CITY OF ALBUQUERQUE

January 29, 2013

**Re: Guardian Storage-Holly
Grading and Drainage Plan
Engineer's Stamp Date 1-24-2013 (C19/D056)**

GRADING & DRAINAGE PLAN

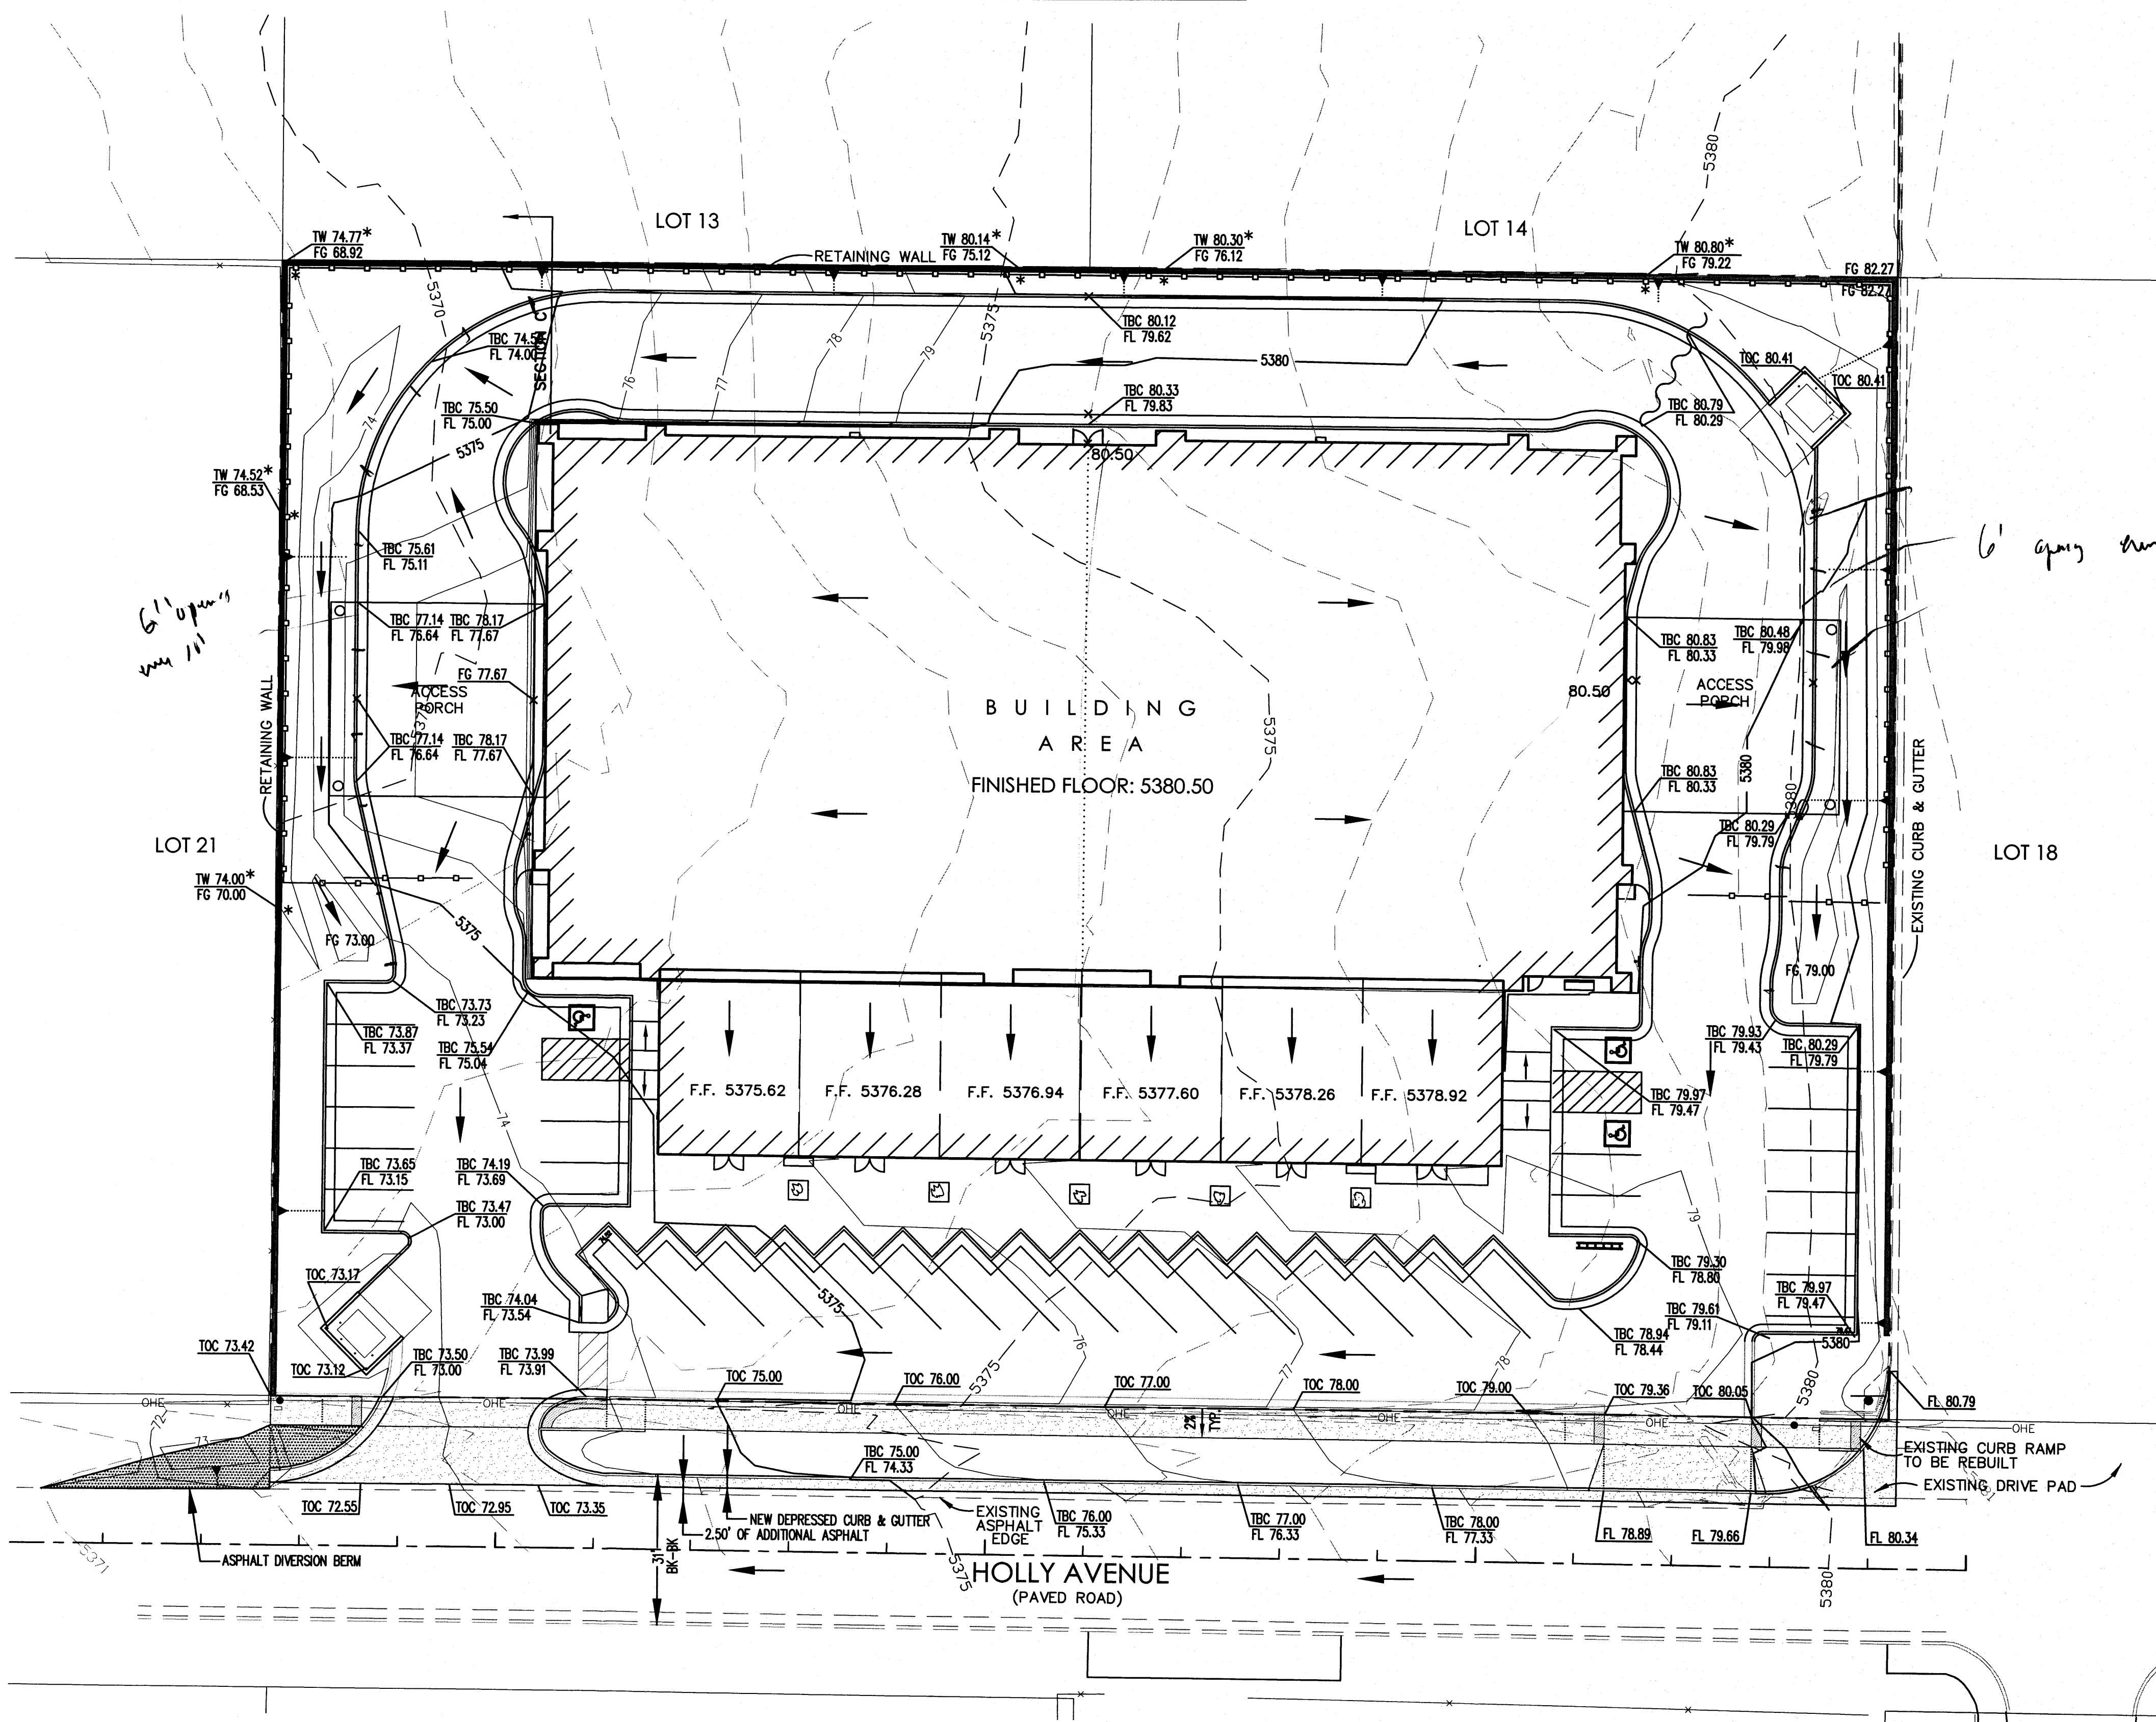
- How are the roof flows entering the landscape areas? How and where are the curb cuts being placed, what are the sizes? A build note should be provided.
